Project Memo

DATE: September 23, 2025
TO: Community Design Solutions, LLC & J&M Discount Towing LLC
FROM: Dustin Kiska, Planner (505)-924-3366 & Daniel Soriano, Planner (505) 924-3935
City of Albuquerque Planning Department
RE: Project # SP-2025-00066 Site Plan – EPC

A1.1
TCL

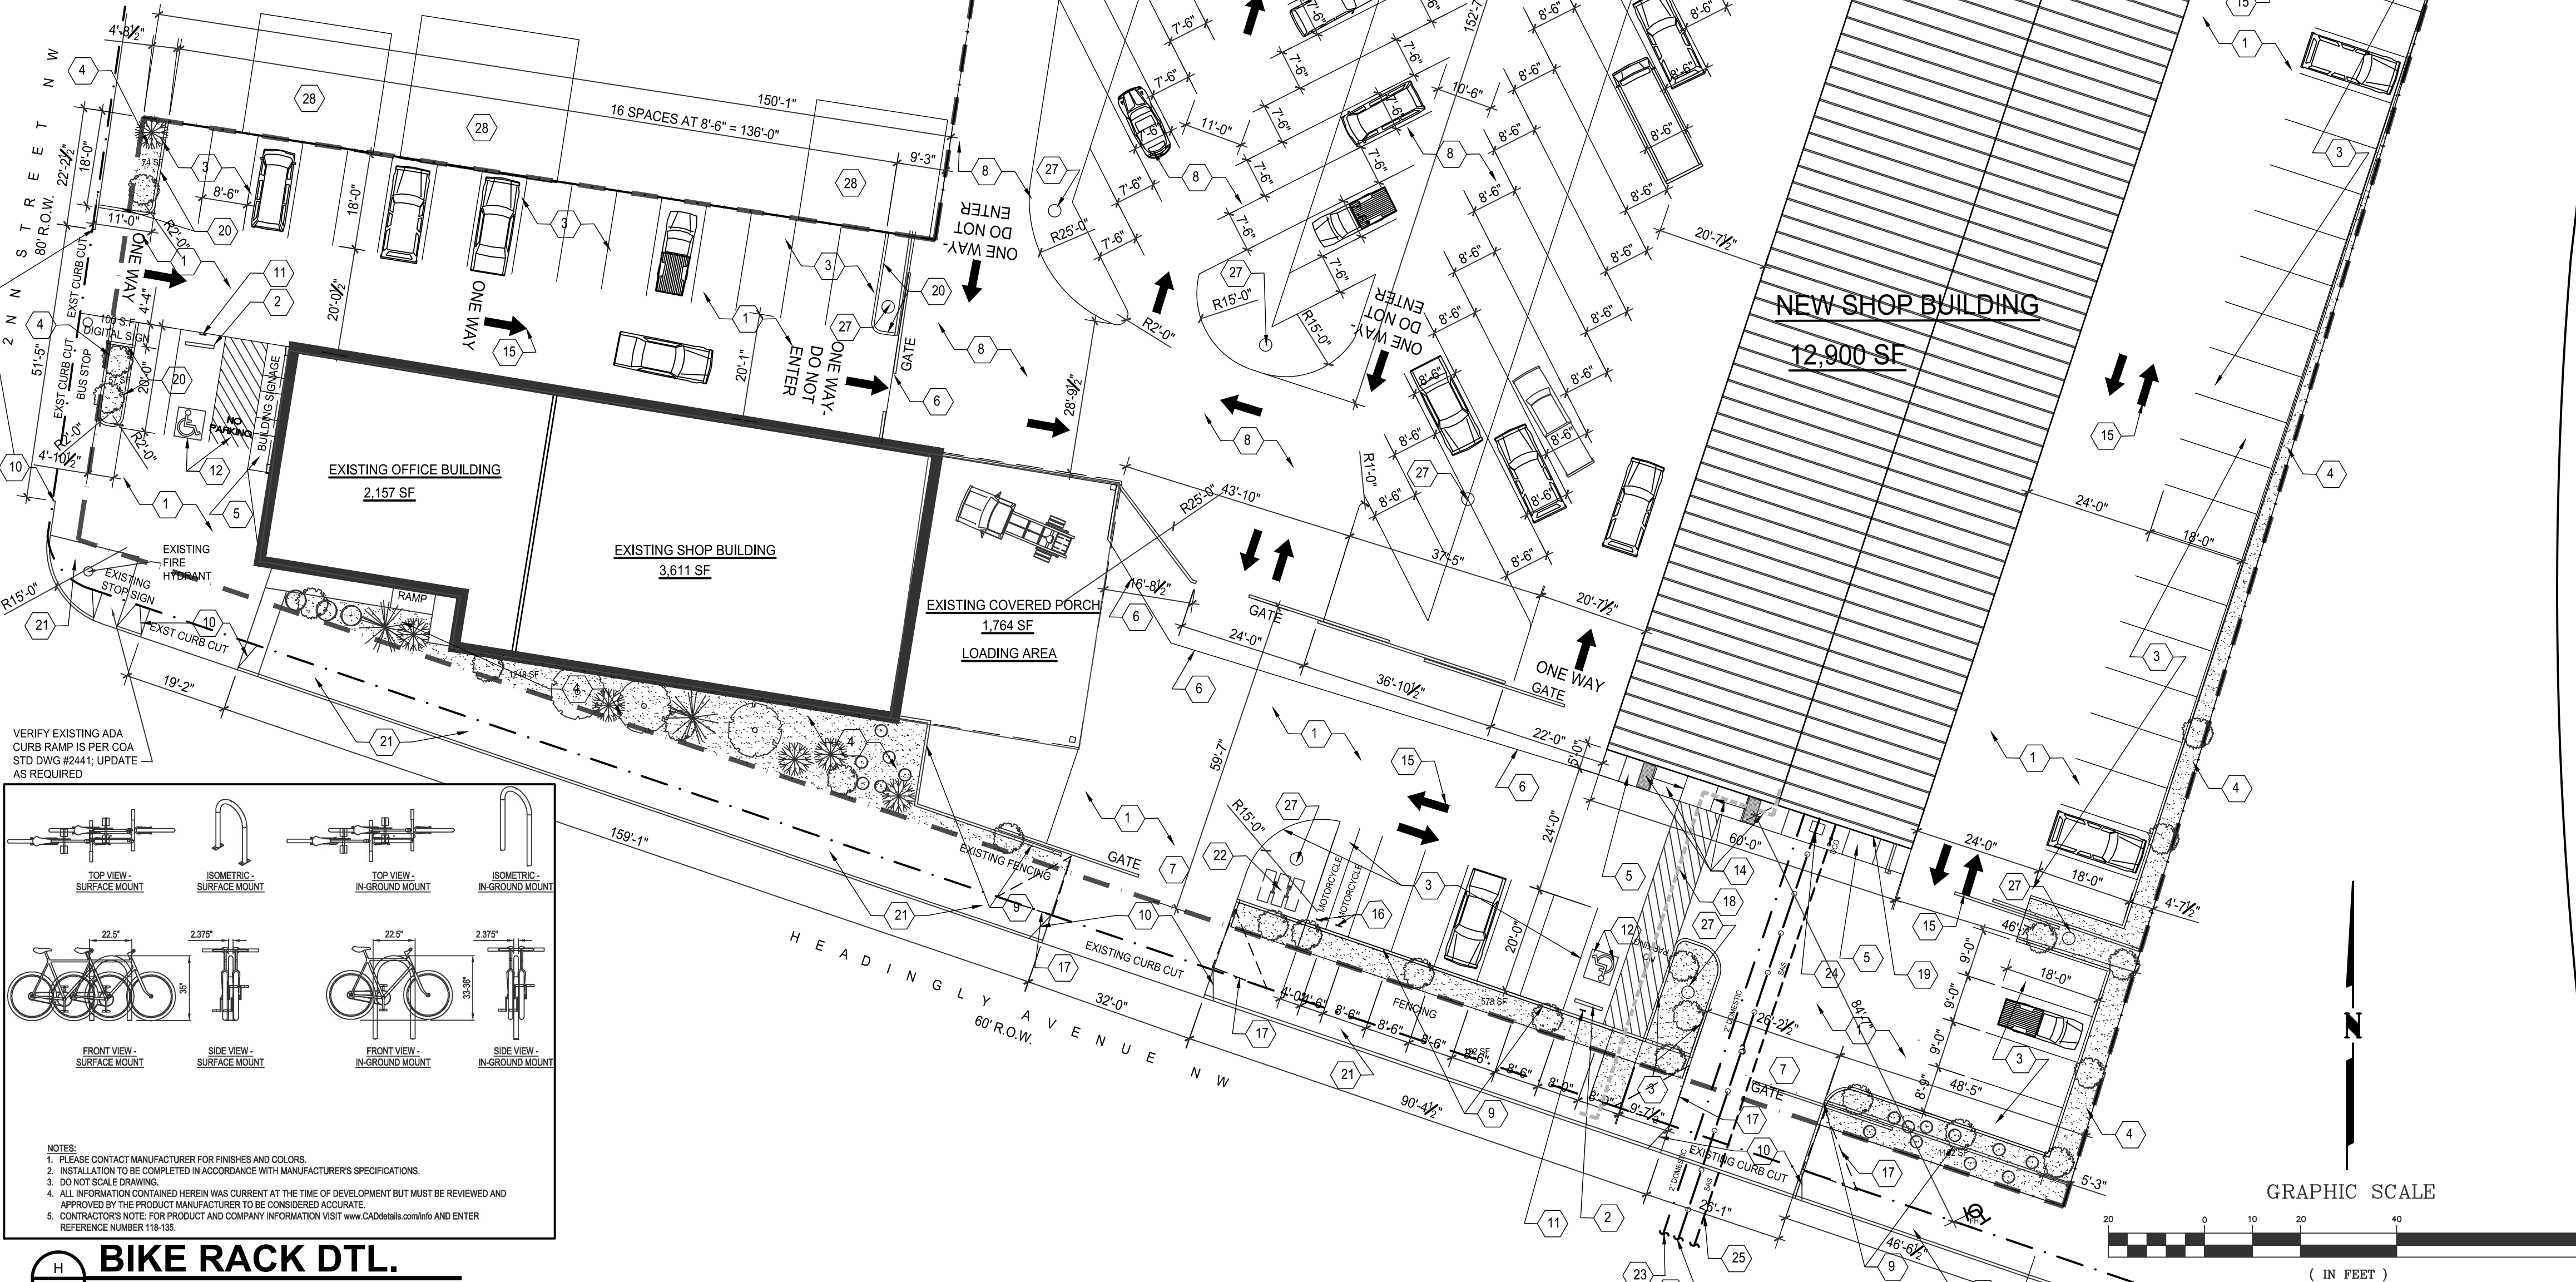
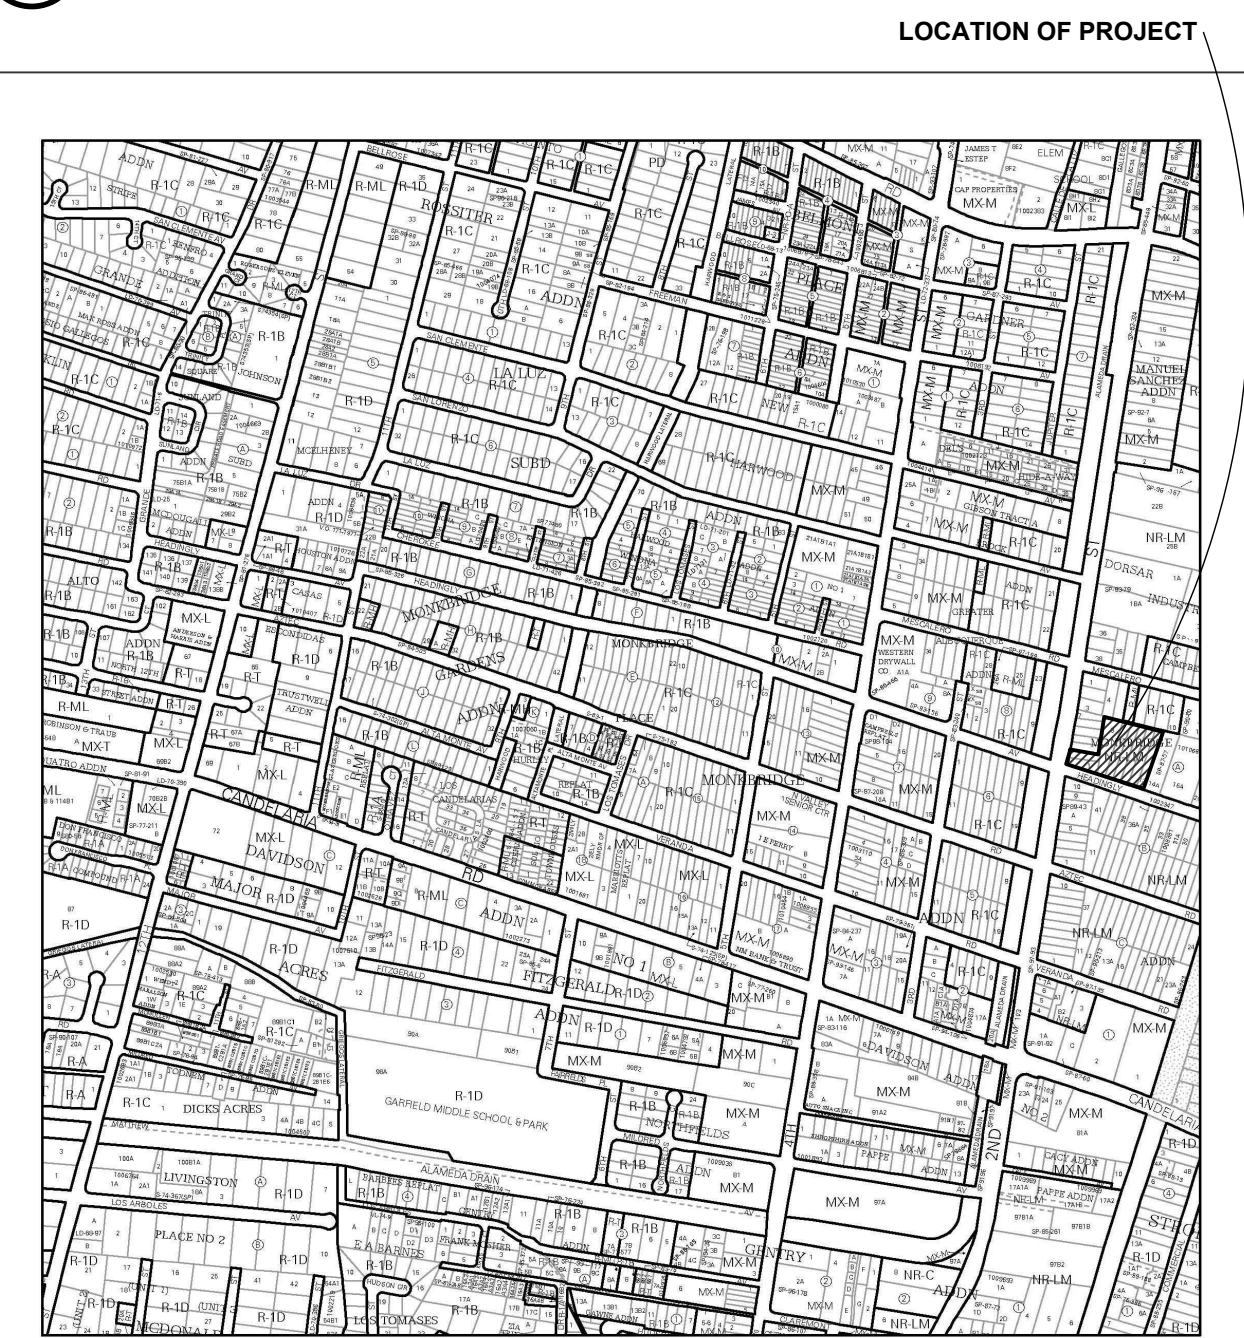
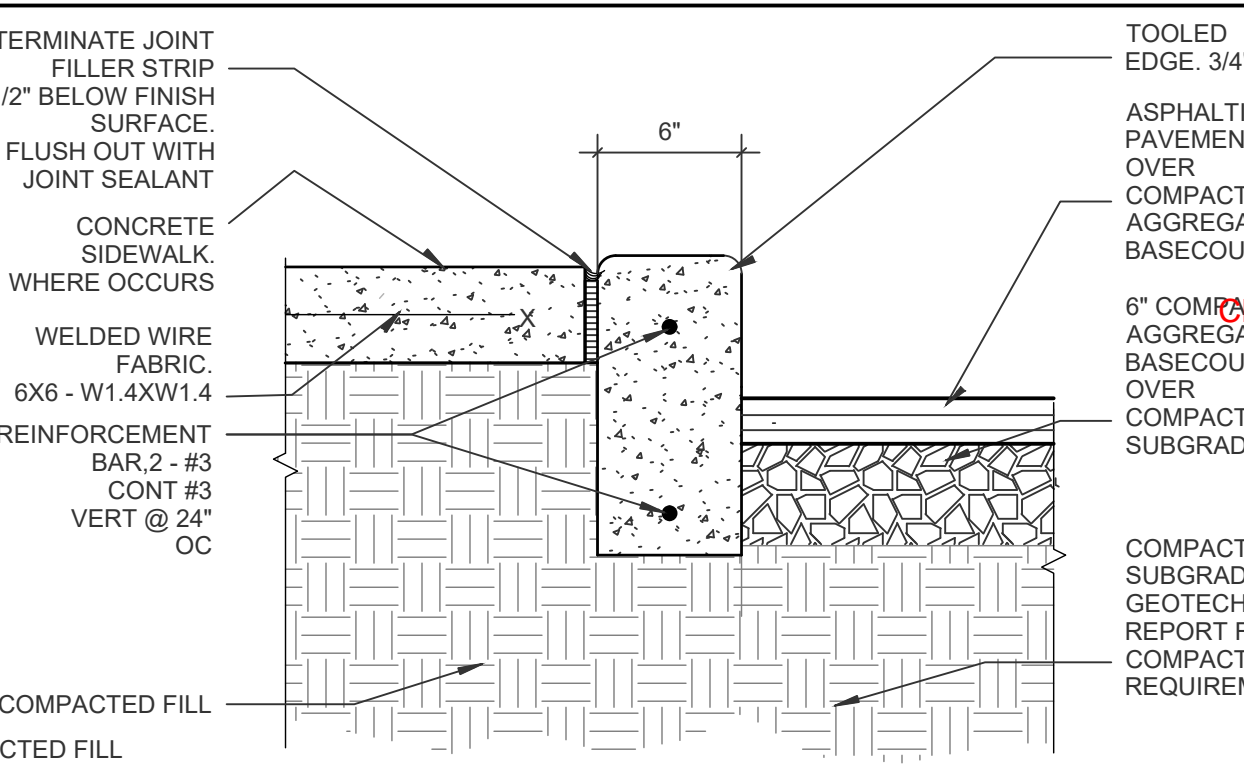
- The request is for a Site Plan – EPC. This needs to be reflected throughout the site plan set title block.

- Site Plan is missing Site Data. Please revise.

- Please move details to a detail sheet, this can include landscape details, and grading and drainage details. Please consider the below detail additions or revisions:

- Please provide a detail of the existing curb cuts to remain. Keyed note (10)

- Please provide a detail of the proposed gate elevations, or 3D axon, showing opening widths and height.

- Please provide details for the selected light pole, including pole height and fixture type, and any lighting specs that may better explain light output that could affect adjacent properties. Keyed Note (27) sheet 1.

- Please provide a detail, elevations, specs for the proposed digital sign, no keyed note provided. Is that existing? Same question with detail, ‘building sign’. Is it existing, and building mounted? (Existing Building Elevation, might show that better, see below Elevation Sheet notes)

- The Site Plan set needs to reflect this case (SP-2025-00066) as opposed to the Building Permit #. You can keep if the building permit information is particularly relevant, but please include the Site Plan EPC Plan # as well.

- Please adjust the spacing between Keyed Notes 9 and 10. There is an overlap of text.

- Please provide a vicinity map on the first sheet, similar to the one seen on the Grading and Drainage plan sheet. Zone Atlas page is ok to include but will not function well as a vicinity map. Please revise it to show the context around the immediate vicinity of the subject site.
- Please provide a calculation for possible on-street parking along Headingly Ave.
- Keyed notes on the solid waste plan are hard to read.
